**KIRKLEES METROPOLITAN COUNCIL
INVESTMENT & REGENERATION SERVICE**

DELEGATED DECISION TO DETERMINE PLANNING APPLICATIONS

Reference No:	2025/62/92848/E
Site Address:	17, Kensington Close, Staincliffe, Batley, WF17 7RL
Description:	Erection of single storey rear extension with balcony, conversion of car port into habitable accommodation and associated alterations
Recommending Officer:	Jennifer Booth

DECISION – Conditional Full Permission

PROPOSED SITE PLAN
SCALE - 1:200

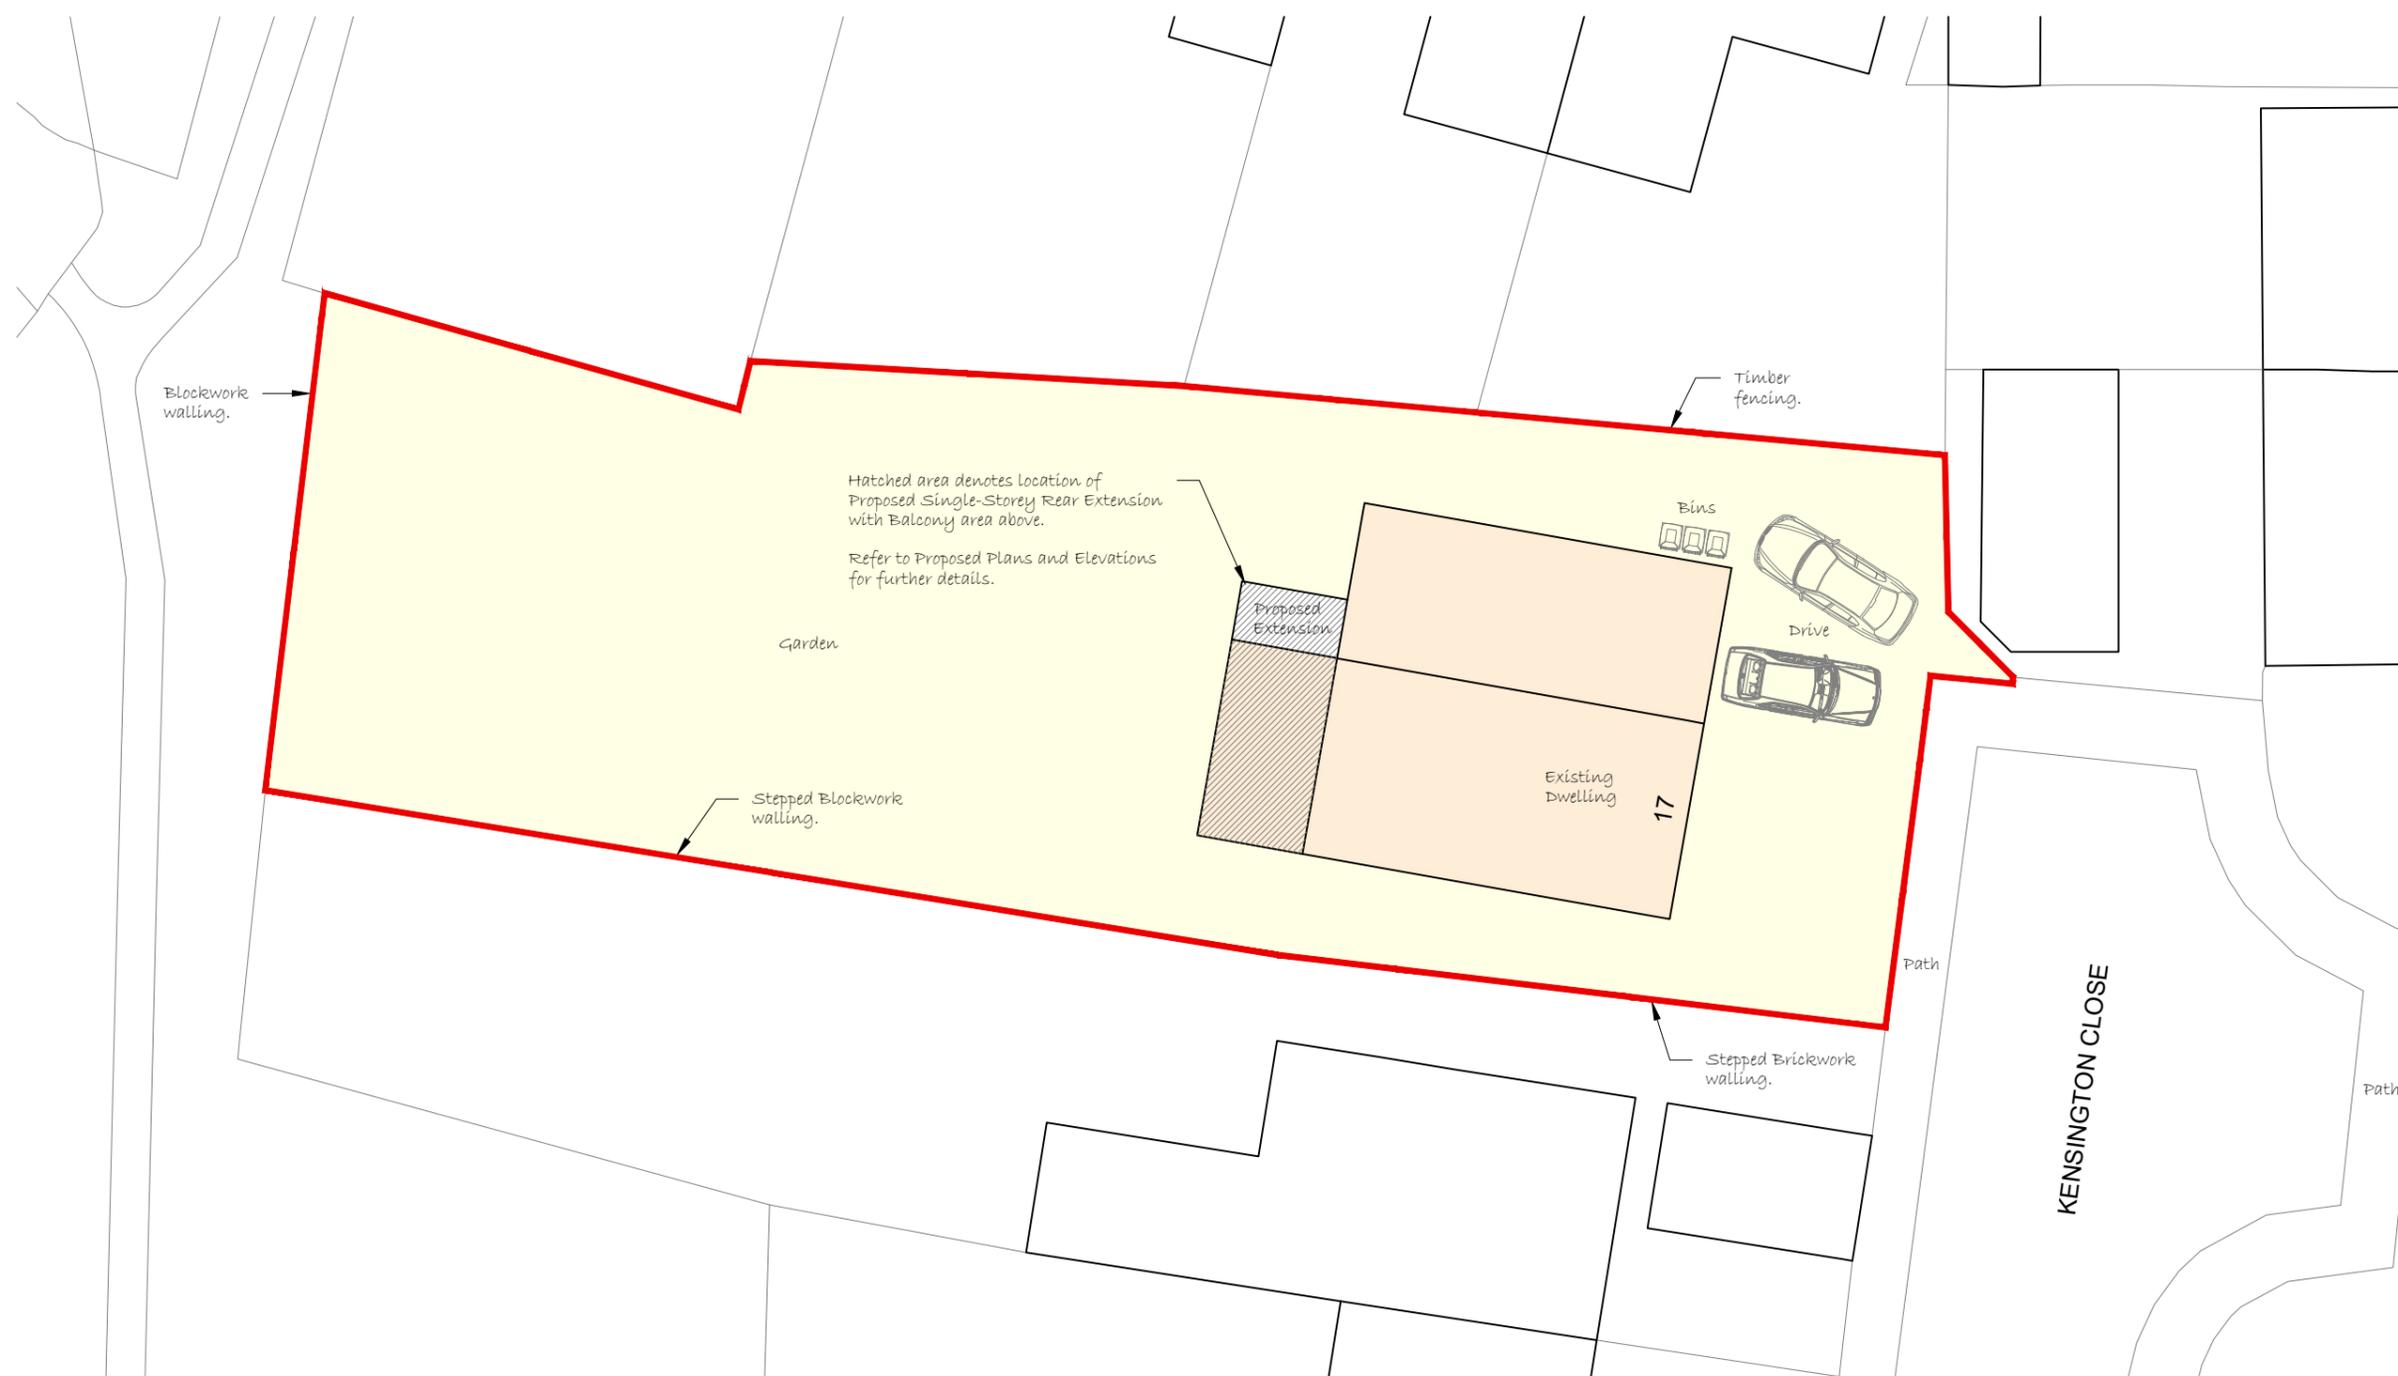
The proposal would result in the removal of the existing car port; however, the submitted plans confirm that two off-street parking spaces would be retained within the site, which helps to mitigate any potential impact on highway safety. It is acknowledged that, in accordance with local parking standards, a dwelling with more than three bedrooms would normally require at least three spaces. In this case, the increase in accommodation is modest and achieved through internal reconfiguration rather than external enlargement. As such, the shortfall in parking provision is considered unlikely to give rise to significant harm to highway safety or the efficient operation of the local road network. Bin storage for the dwelling would not be moved as part of the proposals. As such the scheme would not represent any additional harm in terms of highway safety and as such complies with Policy LP22 of the Kirklees Local Plan along with Key Design Principles 15 & 16 of the House Extensions & Alterations SPD.

port. **Response:** *Although the proposal includes the removal of the existing car port, the plans clearly demonstrate that two off-street parking spaces would be retained, which helps to mitigate any potential impact on highway safety. It is acknowledged that, under local standards, a property with more than three bedrooms would normally require at least three parking spaces. However, the increase in accommodation is modest, achieved through internal reconfiguration rather than external enlargement, and therefore the shortfall is considered unlikely to result in significant harm.*

Drawn by AM	Date 10/25	App'd -
Drawing no PL-03	Project no 25-984	Scale @ A3 1:100
		Rev -

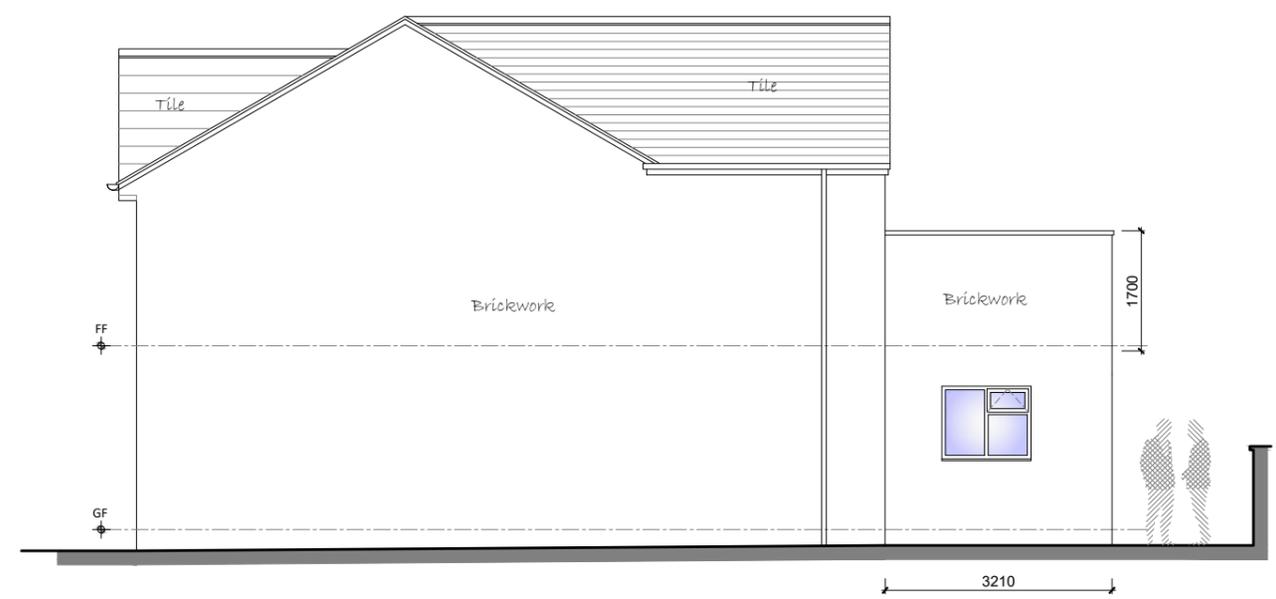
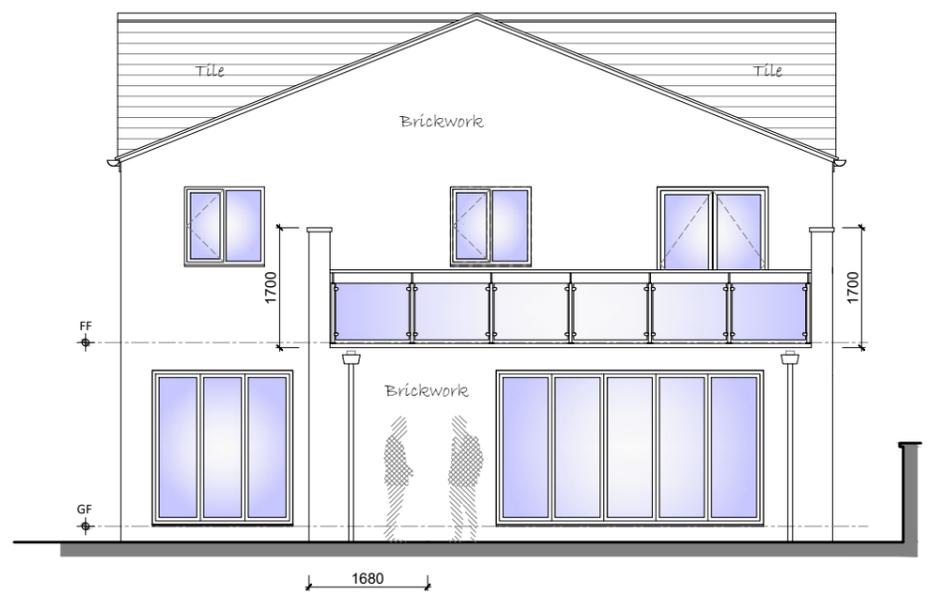
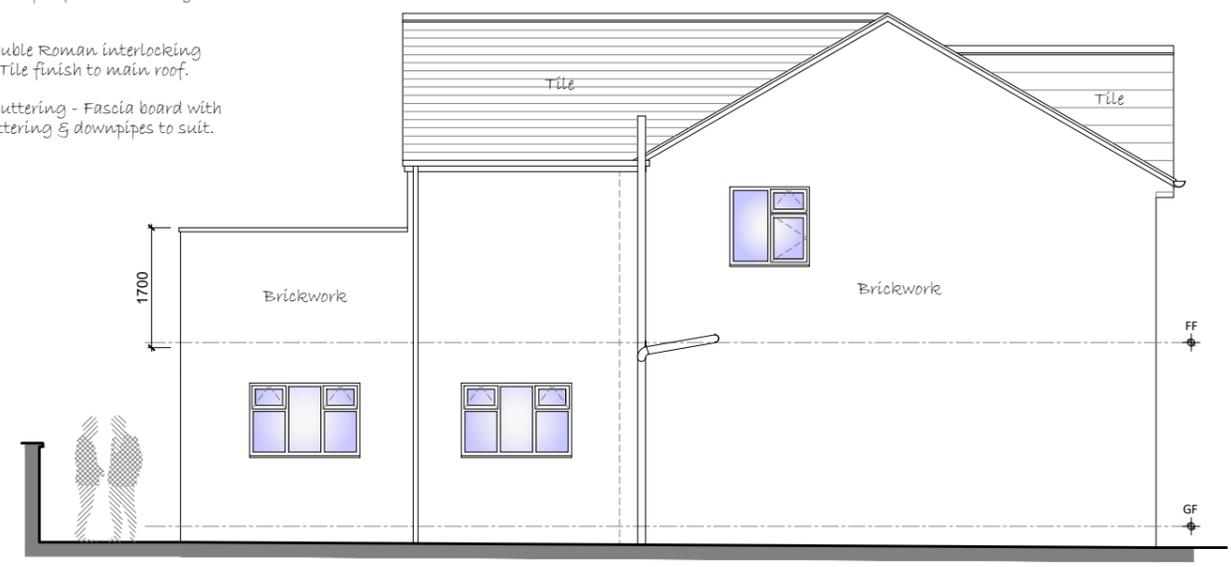
The proposal involves alterations to the front elevation, including the rearrangement of fenestration, the introduction of a gable feature, the enclosure of the existing car port to provide additional living accommodation, and refacing the principal elevation in stone. While stone is not a characteristic material within this cul-de-sac, it is present in the wider area. Given the siting of the property at the end of the row and its status as a detached dwelling, the use of stone is considered justifiable and would not appear incongruous. The host property has previously been extended with a two-storey side extension incorporating the car port, as well as a two-storey rear extension and a single-storey addition. The proposed changes would subtly update the appearance of the property, introducing a more contemporary design while remaining proportionate to the existing building.

The proposal also includes the nominal widening of the existing single-storey rear extension and alterations to its roof to facilitate the formation of a balcony above. These changes would remain subordinate to the main dwelling and would not significantly increase the overall bulk or massing of the property.

The neighbouring properties to the north have their rear elevations facing the side elevation of the host property with a separation of some 14m. The proposals would not reduce this space. There are no windows proposed which could overlook the neighbouring dwellings. The balcony proposed includes screening which would prevent overlooking towards the neighbouring

The front wall shall be finished in natural stone and the side and rear walls shall be constructed using matching materials to ensure that the extensions harmonise with the host property as using alternative materials would look out of place within the street scene.

3. The front wall shall be constructed using nature stone and the external walls and roofing materials of the side and rear walls of the rear extension hereby approved shall in all respects match those used in the construction of the existing building.

Drawn by	Date	App'd	
AM	10/25	-	
Drawing no	Project no	Scale @ A3	Rev
PL-02	25-984	1:100	-

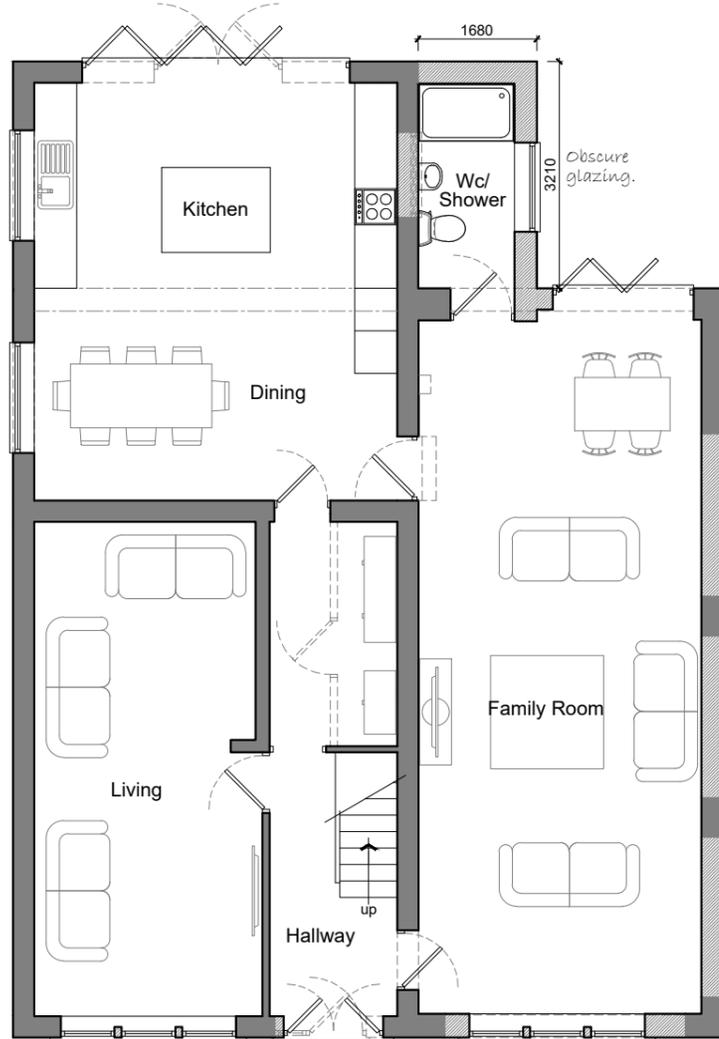
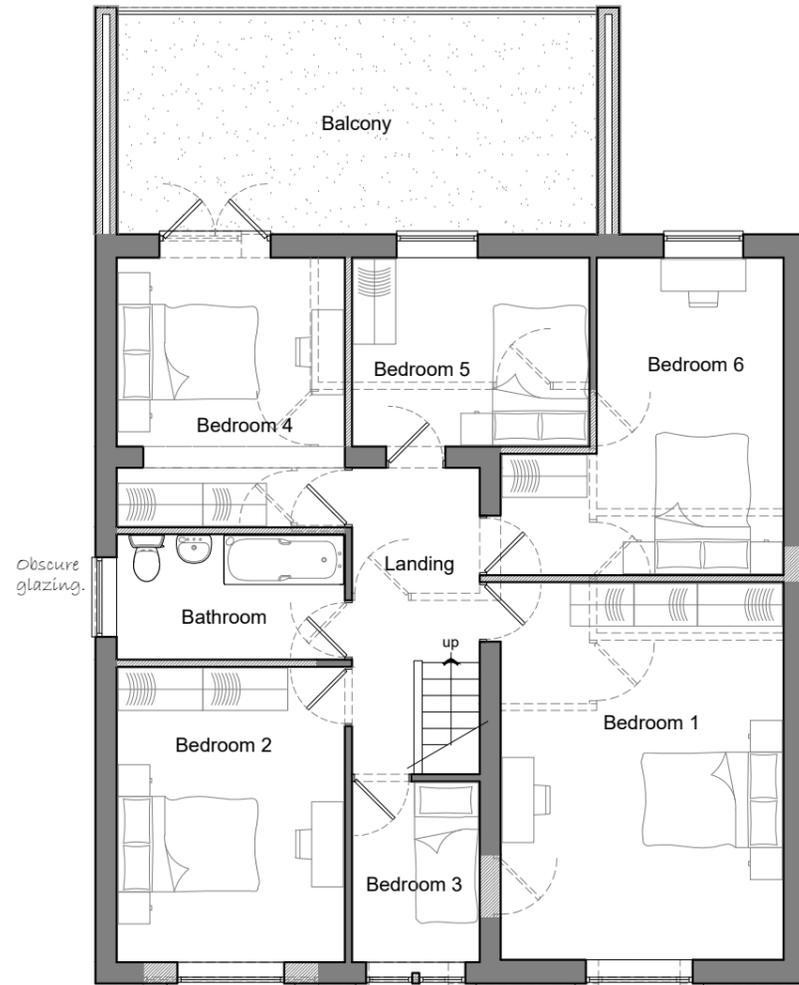
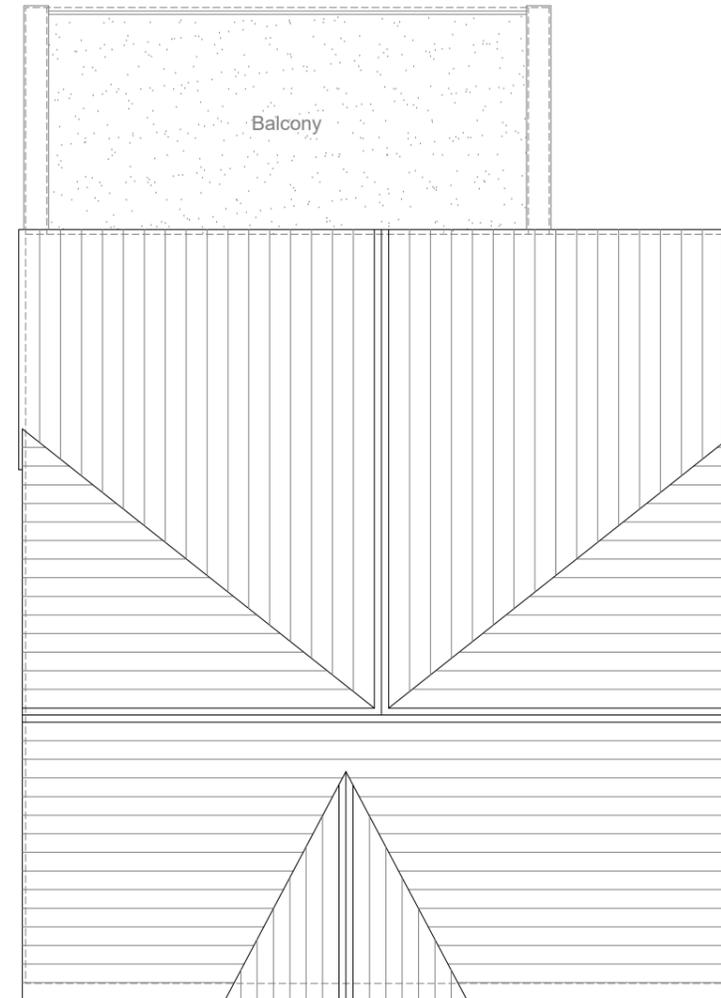
The existing single storey rear extension would be increased in width by an additional 1.7m further across the rear. The balcony would be formed over the existing and proposed extension with 1.7m high walling to each side to provide screening and a 1m glazed balustrade.

The changes proposed to the front of the dwelling would have no impact on the adjacent property. The alteration of the roof over the existing rear extension to form a balcony includes screening and is sufficiently separated from the adjacent property to avoid any overshadowing, overbearing or overlooking.
